April 13, 2015

**Subject: Century Tire Plaza – 195 Kennebec Street
Project ID# 2015-027
Review Comments Received April 8, 2015**

SHEET TITLE: **SITE LAYOUT AND UTILITY PLAN**

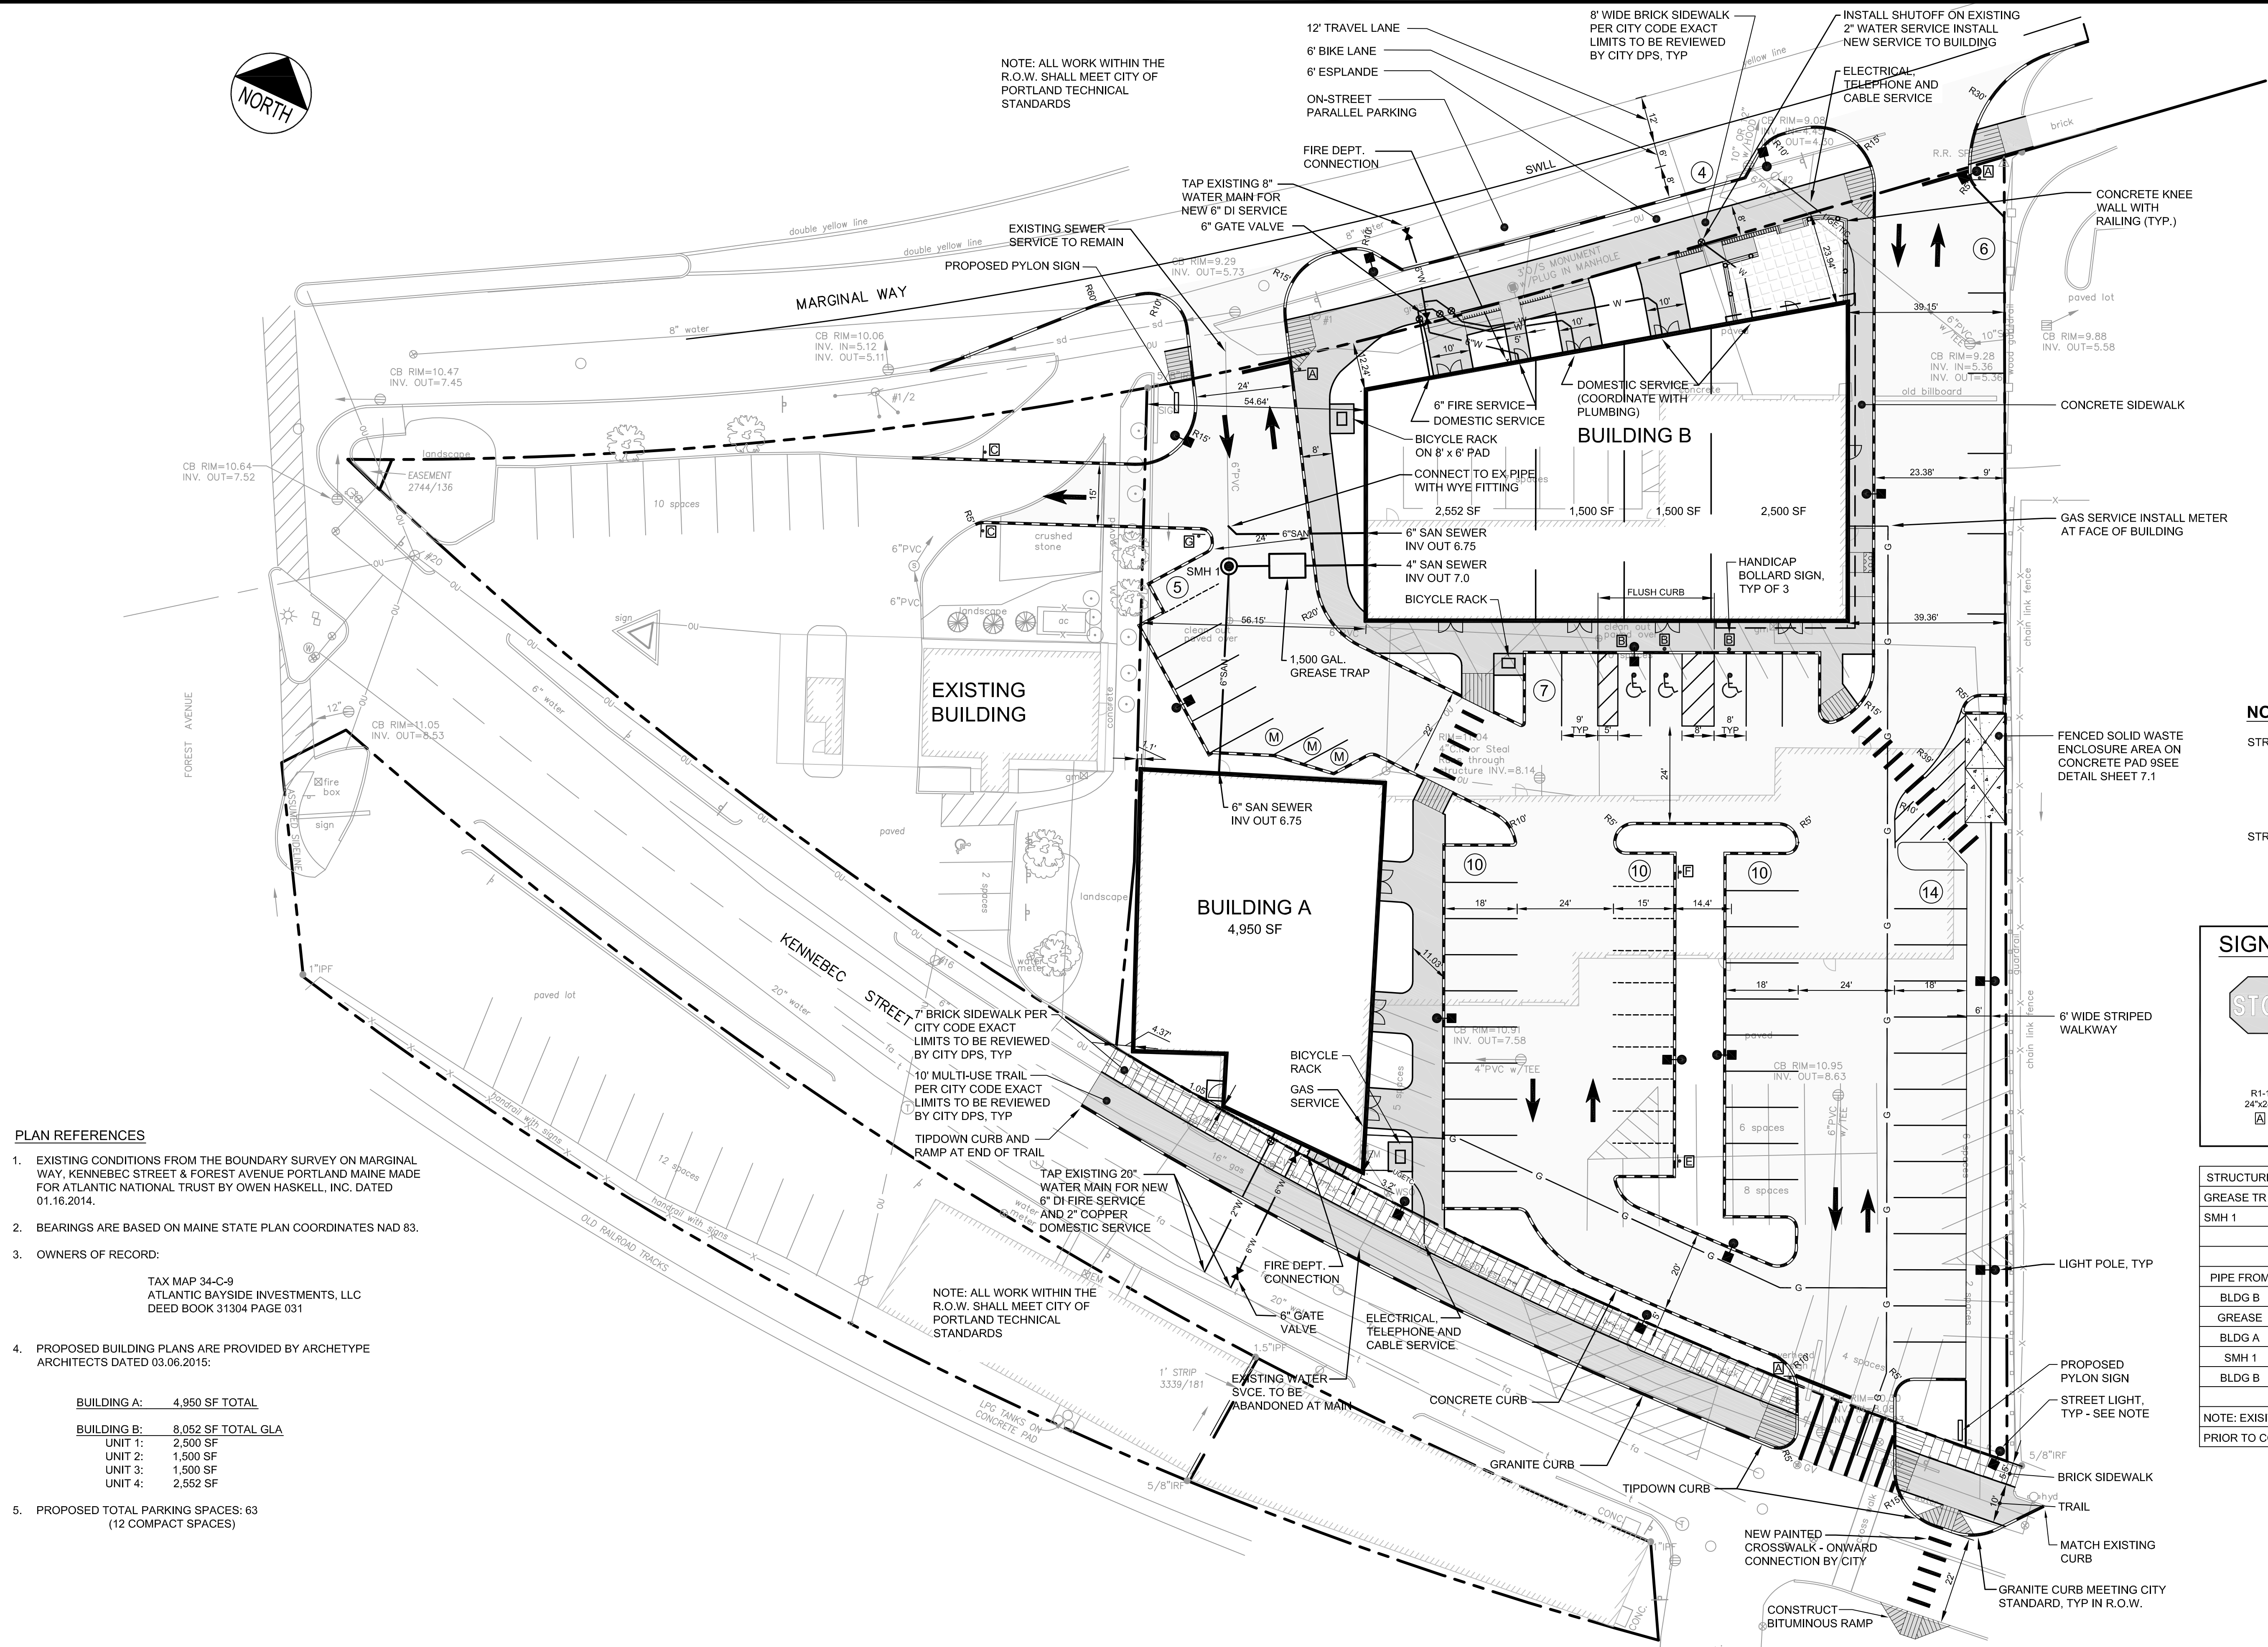
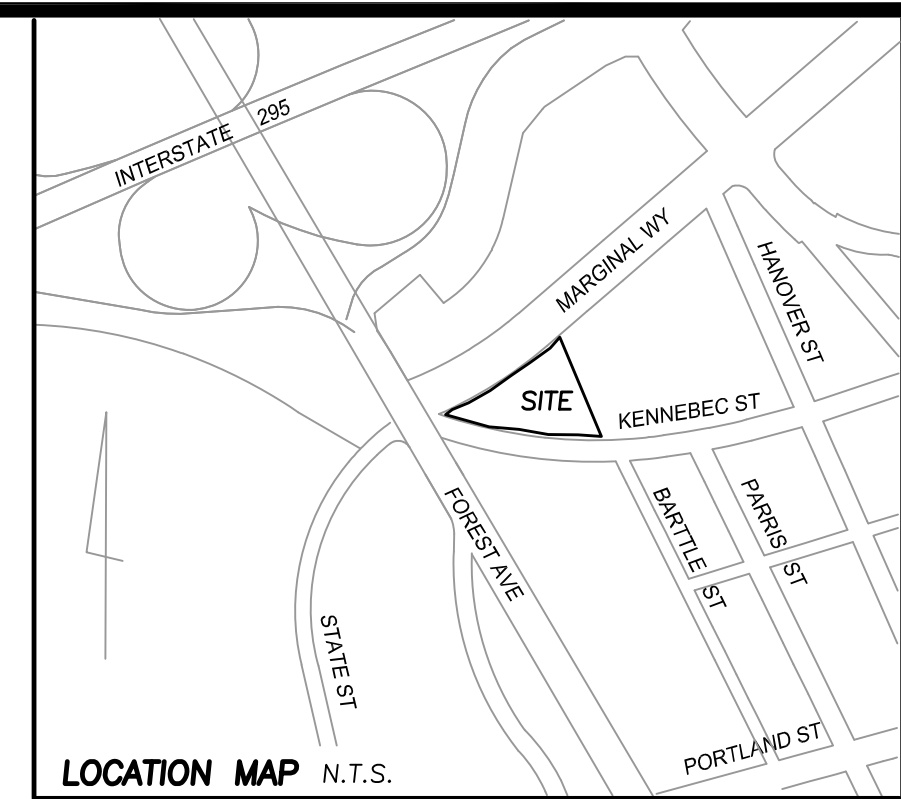
As requested, the plans have been revised to show a connection from existing Catch Basin A to new Catch Basin 3, which will discharge to Marginal Way. Additional notes are required regarding the abandonment of the pipe between Existing Catch Basin A and the existing catch basin in Kennebec Street.

The pipe and catch basin penetrations should be capped at Catch Basin A and at the connection in Kennebec Street; and preferably the pipe is removed or infilled with a flowable fill.

- *A curb extension shall be provided on Kennebec Street at the location of the sidewalk ramp/crosswalk such that the handicap ramp is not located within the 10-foot path area. The applicant shall submit plans for review and approval by the City.*

The plans should incorporate a full ADA compliant crosswalk on Kennebec Street between the site and Brattle Street (this crosswalk currently exists). Status: The plans should also include the construction of a ADA compliant ramp on the south side of the crosswalk on Kennebec Street. Plans shall be provided to the City for review and approval.

The configuration of the six parking spaces located along the Enterprise property boundary are non-standardized and dimensional standards are unclear and I would prefer a more traditional layout. Status: The applicant shall revise the configuration of these spaces to conform to standard parking space orientation. Plans shall be provided to the City for review and approval.

Please add notes to the plan denoting the street light specifications for both Marginal Way and Kennebec. This will help our inspectors during construction.

Notes have been added on the revised plans stating that the pipe penetrations into the referenced structures will be capped and sealed, as requested.

- The applicant will provide documentation to assist in support of the City's proposed Traffic Schedule changes, as requested.
- The curb line on Kennebec Street has been extended to remove the handicap ramp from the multi-use trail, as requested.

A ramp has been added on the south side of Kennebec Street.

The parking stalls in this area have been revised to further clarify the dimensions and ensure that they meet the city standards. We will continue to work with the City as necessary to ensure that the parking stalls will function as proposed within the site circulation.

A note has been added to the Site Layout and Utility Plan with the model numbers for the street lights and referencing the City Technical Manual Detail.
